Appeal Decision

Appeal Ref: APP/R5510/W/23/3315737

42 Field Heath Road, Uxbridge, Hillingdon UB8 3NG

- The appeal is made under section 78 of the Town and Country Planning Act 1990 (the Act) against a refusal to grant planning permission.
 - The appeal is made by Mr Gary Wynne against the decision of the Council of the London Borough of Hillingdon.
 - The application Ref 17611/APP/2022/993, dated 23 March 2022, was refused by notice dated 9 December 2022.
 - The development proposed is the demolition of a two-storey building with rear dormers used as an existing bed and breakfast, and the erection of stepped back three-storey residential development comprising of seven flats, alterations to existing drop kerb, all associated external works and landscaping.
-

DESCRIPTION:
PROPOSED ELEVATIONS

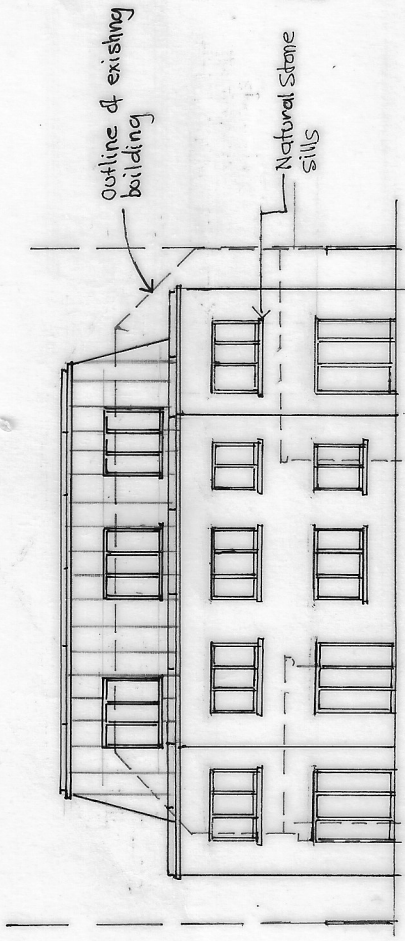
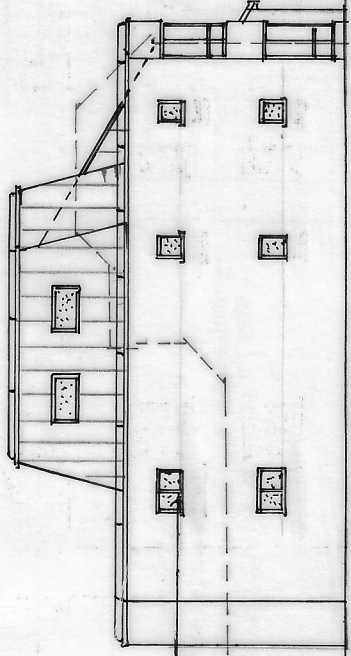
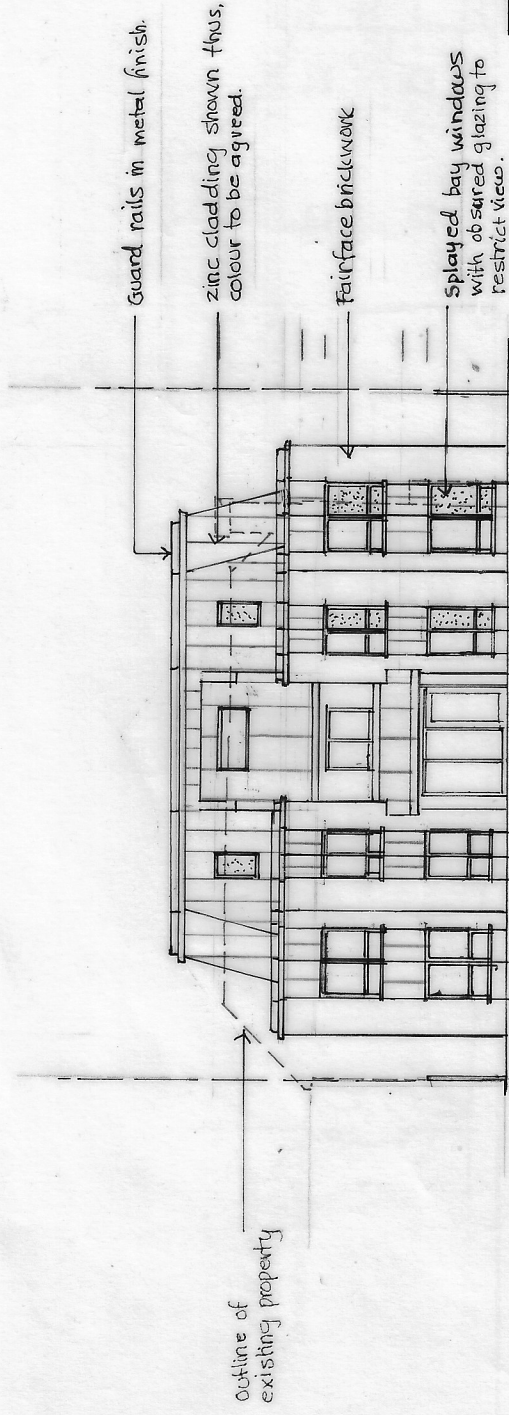
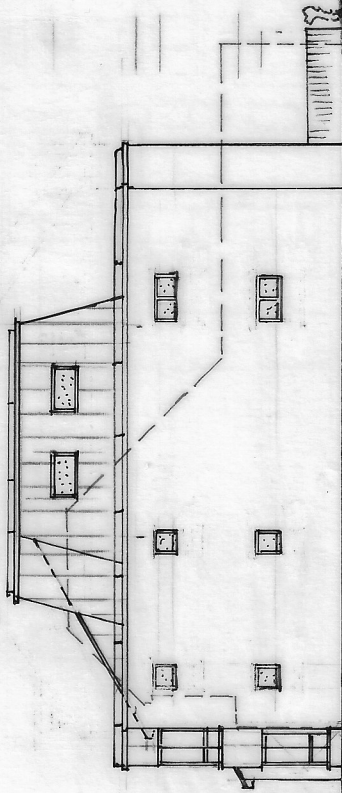
7. The proposal includes windows to habitable rooms, including living rooms, at first and second floor. This would have the effect of introducing direct overlooking from the first-floor triangular bay windows of both bedrooms in flat 4 towards the rear garden of No 40; and direct overlooking of the rear garden of 3 Newlyn Close (No 3) from the first-floor bedroom windows to flat 5 and living room windows to flats 4, 5 and 6, and from the second-floor bedroom and living room windows to flat 7.

8. The effects of direct overlooking towards No 40 could be addressed by planning conditions requiring the use of obscure glazing to the relevant sashes and preventing their opening. However, this would not be an appropriate solution to prevent overlooking from those first and second-floor windows in the rear of the proposed building facing No 3 where they provide the sole or principal outlook from the relevant rooms. Moreover, preventing views from those windows through the use of obscure glazing would create harmfully oppressive living conditions for the future occupiers of flats 4, 5, 6 and 7.

10. The effects of direct views from the first and second-floor windows in the side elevations of the proposed building towards No 1 and the rear garden of 46 Pield Heath Road (No 46) could be addressed by planning conditions requiring the use of obscure glazing to the relevant sashes and preventing their opening. Views towards No 2 and 2 Micawber Avenue would be at oblique angles and these, along with other views towards more distant properties and their gardens would not result in significant harm to occupiers' living conditions. Nevertheless, the proposal would create an unacceptably harmful loss of privacy as a result of overlooking towards the rear garden of No 3.
